Subject: Berrima Hotel (SSD-66876472) – Environmental Impact Statement (EIS)

Detailed advice to DPHI Planning & Assessment regarding the Berrima Hotel (SSD-66876472) – Environmental Impact Statement (EIS)

Lower Basement

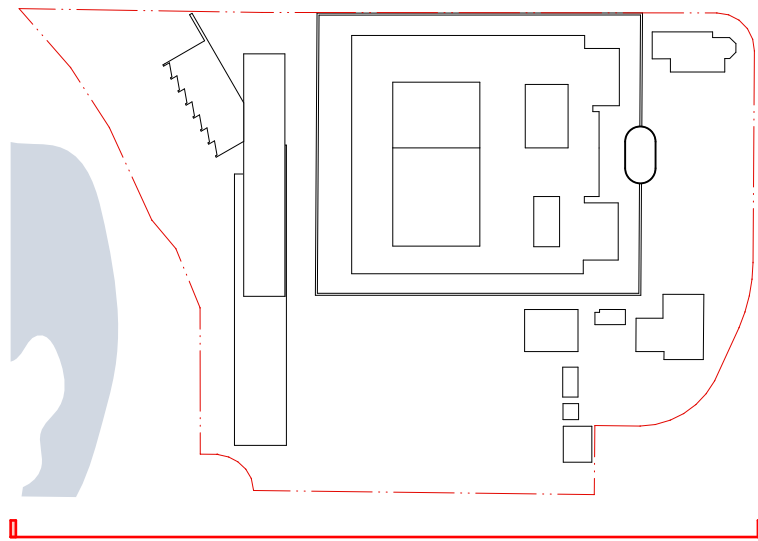
DPHI should request the proponent provide an assessment of the basement dewatering pump(s).

Section 4.41(g) of the *Environmental Planning and Assessment Act 1979* excludes a requirement for a Water Supply Works Approval under the *Water Management Act 2000*, provided the water supply works (in this case dewatering pumps) are assessed during the SSD assessment process and prior to determination.
